## DECISION DELEGATED TO HEAD OF PLANNING

**Application No:** H16-0251-25      **Applicant:** Mr S Brown

**Proposal:** Conversion of loft to habitable space, internal alterations, addition of dormer window to west elevation, re-roof & reinstatement of historic windows

**Location:** Monks House Bourne Road Spalding

| DRAWING TITLE:<br>LOFT PLANS                        |                |                  |                 |

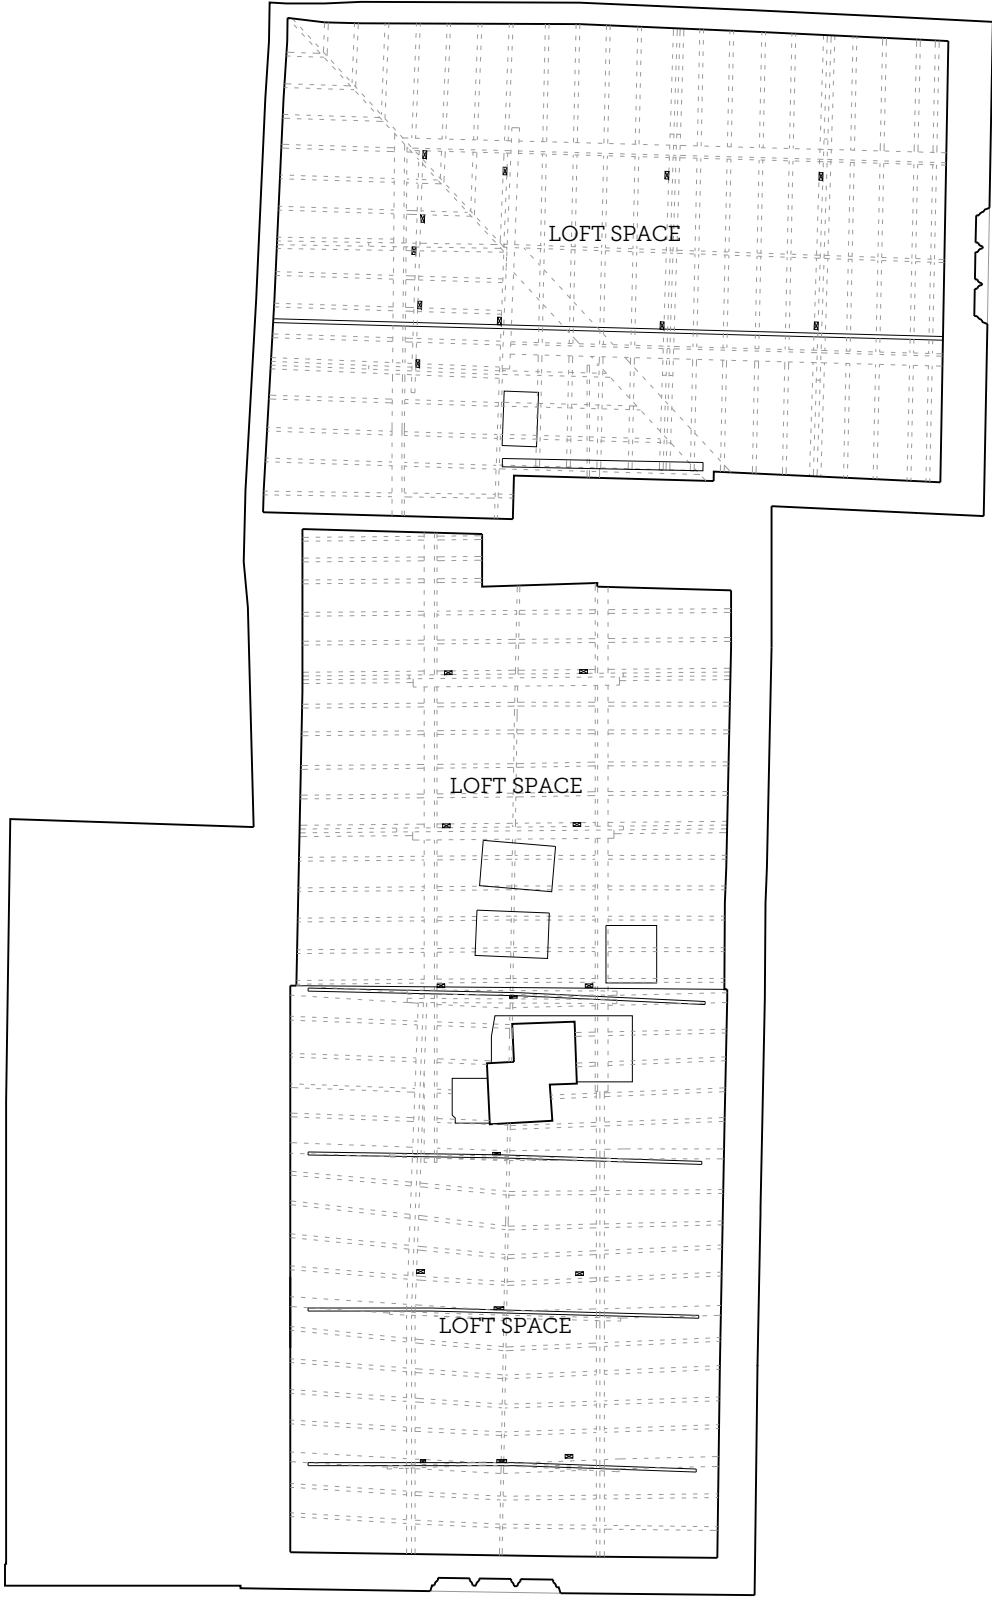
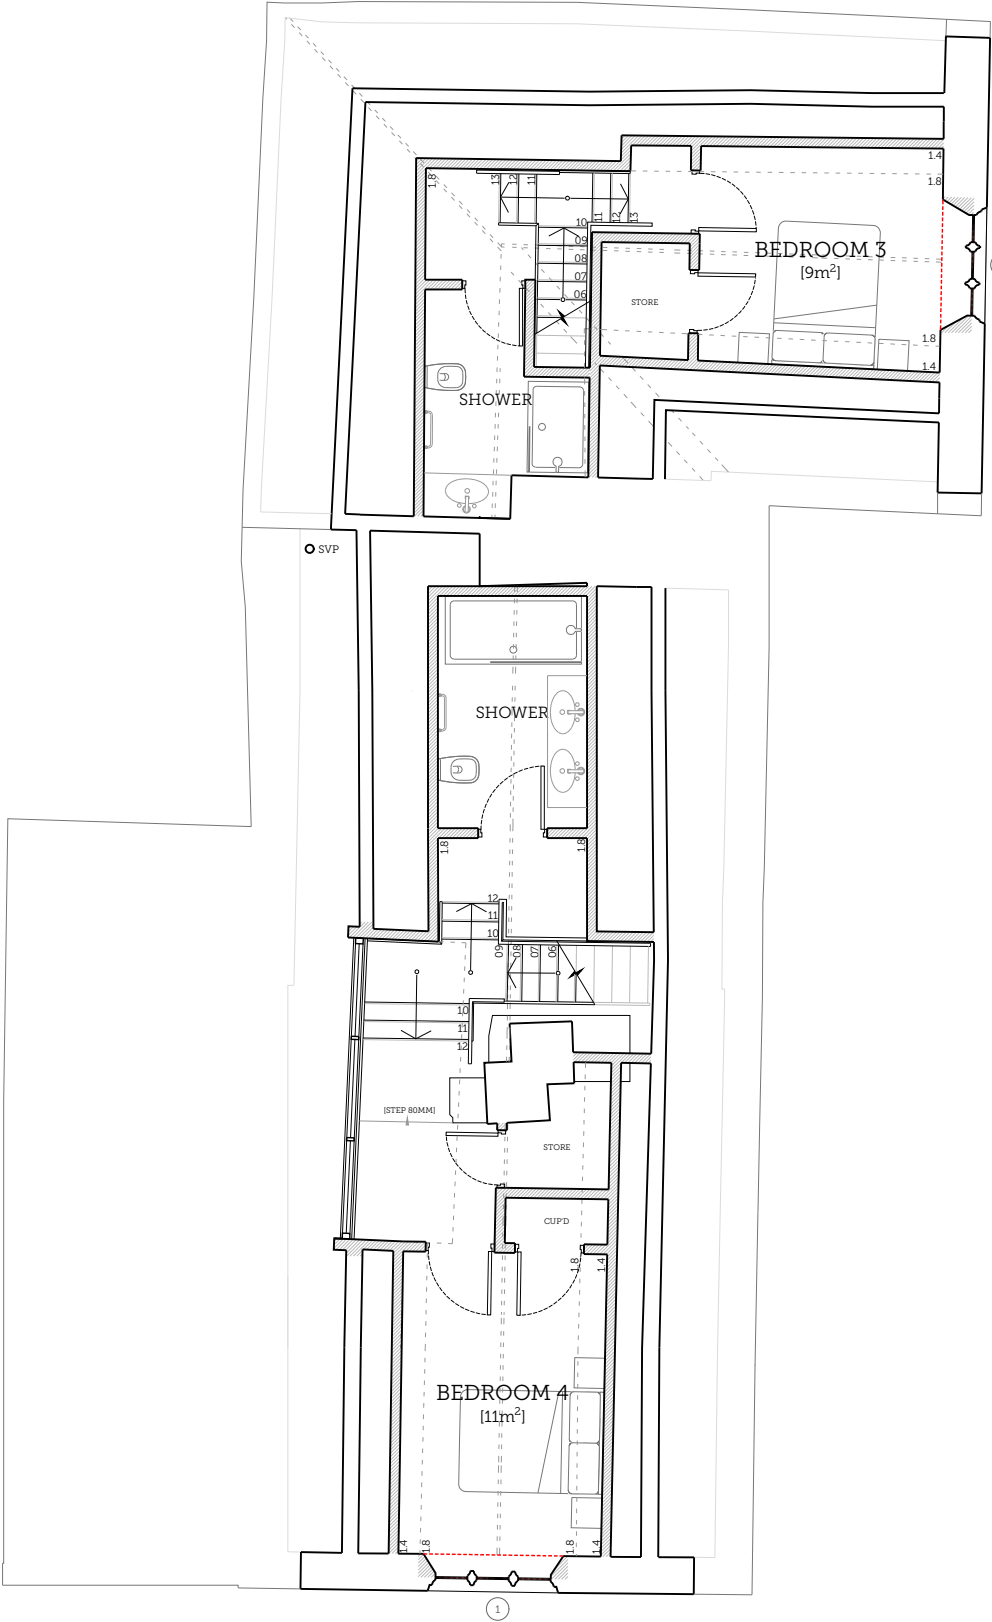
The box dormer window would project from the west elevation. It would measure 4279mm (width) with a height and depth of 1450mm.

This box dormer is required to provide sufficient headroom when accessing the new bedroom 4. This is one of two bedrooms that are proposed in the attic. Each bedroom would have its own access, formed via the creation of new wooden stairs in the landing and first floor living/bedroom respectively, and bathroom. To enable this change, two currently bricked up windows are to be reinstated. It should be noted that these windows historically served attic bedrooms, but the attic and windows have been disused since a fire in the 1970s.

**Dormer Window:** The Heritage Statement (HS) acknowledges that the proposed dormer window is an 'alien form to a building of this period'. We agree with this assessment and further assert that the proposal would cause an unacceptable level of harm to the building's special interest. Therefore, we cannot support this proposal. While we recognise that improved access would benefit the future use of the building, any harm requires clear and convincing justification, which we do not consider has been sufficiently provided. National policy emphasises that great weight should be given to an asset's conservation. Therefore, less harmful options for access into the attic should be considered, and it may be that full access to all parts of the attic is not possible.

**Windows:** The HS describes the opening up of windows at attic level. While we do not object to this in principle, further detailed information is required to show the design and specification of the proposed window to assess the impact on the surrounding historic fabric. The drawings also show that the ground floor kitchen window will be replaced. However, the age of the existing window is unknown, and the proposed new window is not described. Further information is required to understand the proposal and assess the impact of the window replacement.

It is considered that the proposed dormer window would introduce a highly incongruous element, which completely juxtaposes with the historic nature of the building, thereby harming the significance of the heritage asset. In this instance, less than substantial harm has been identified.
